Consultant Advice Notice

Project:	Waterloo Metro Quarter Development – Building 1	Project No.	1024873
Subject:	Response to Submission CoS 41	Doc No.	RPT-005
Author:	David Collins	Date:	27/01/2021
Attention:	Mirvac Development	Revision:	A

This Consultants Advice Notice has been prepared to provide a response to the City of Sydney’s Response to Submission item 41 (as follows).

Level 13

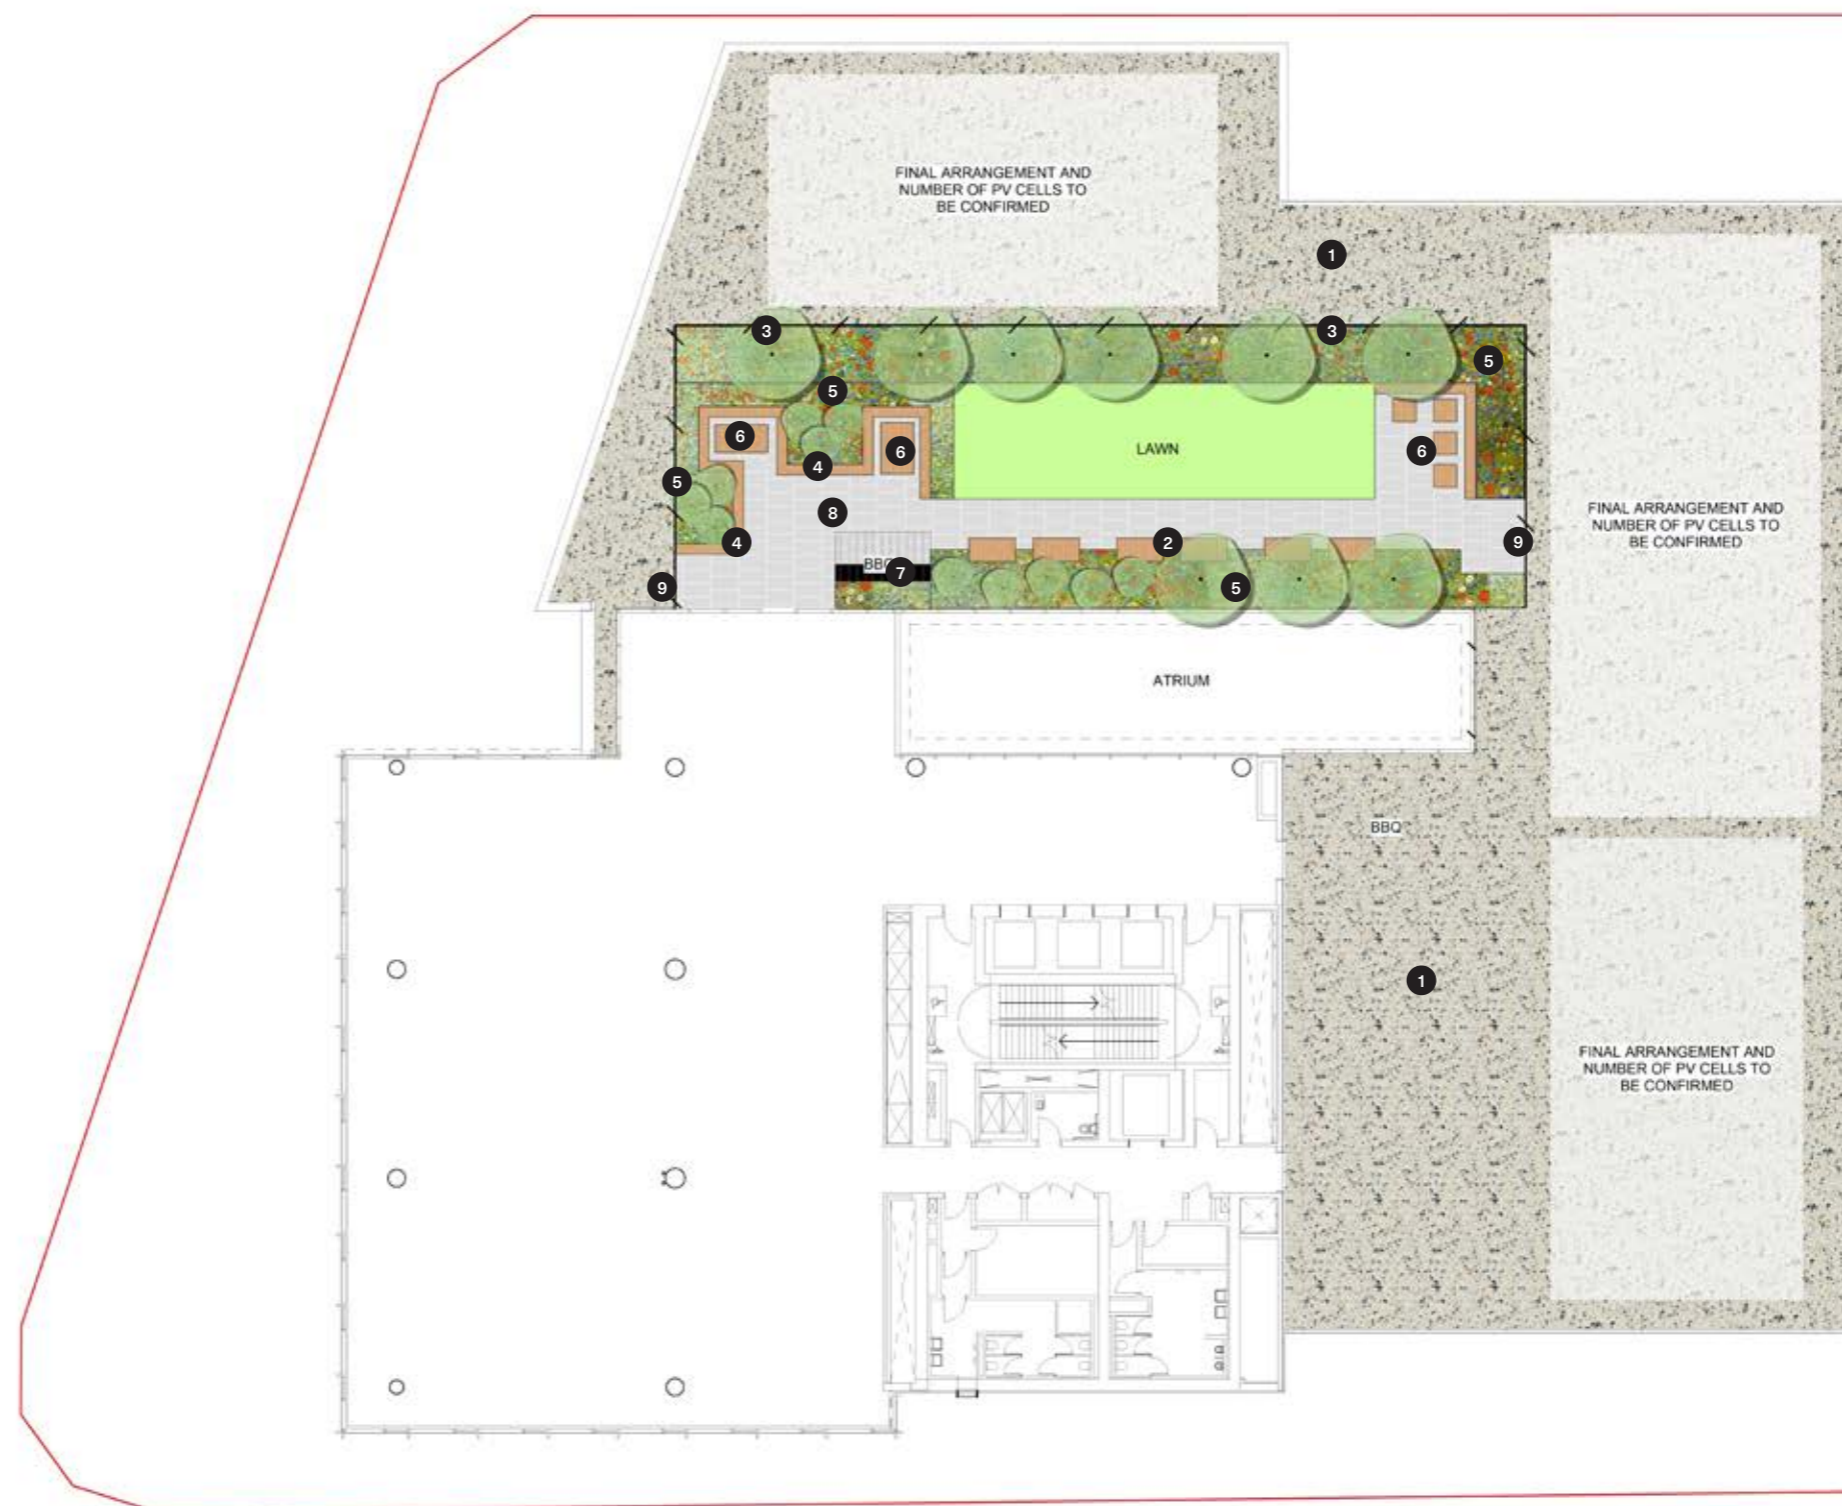
The roof terrace to level 13 of Building 1 includes an accessible area that has been indicatively designed (subject to tenant fit-out), and an expanse of gravel roof with photovoltaics. Studies show that co-locating photovoltaics and green roofs can greatly improve the performance of the PVs, whilst supporting habitat and biodiversity. This should be considered for this roof.

The current design, to have separate green roofs and PV areas on the roof, is the preferred approach and maximises the benefits of both. The green roof can be enjoyed and maintained without the clutter of PV panels, and the PV system is installed, operates, and is maintained efficiently.
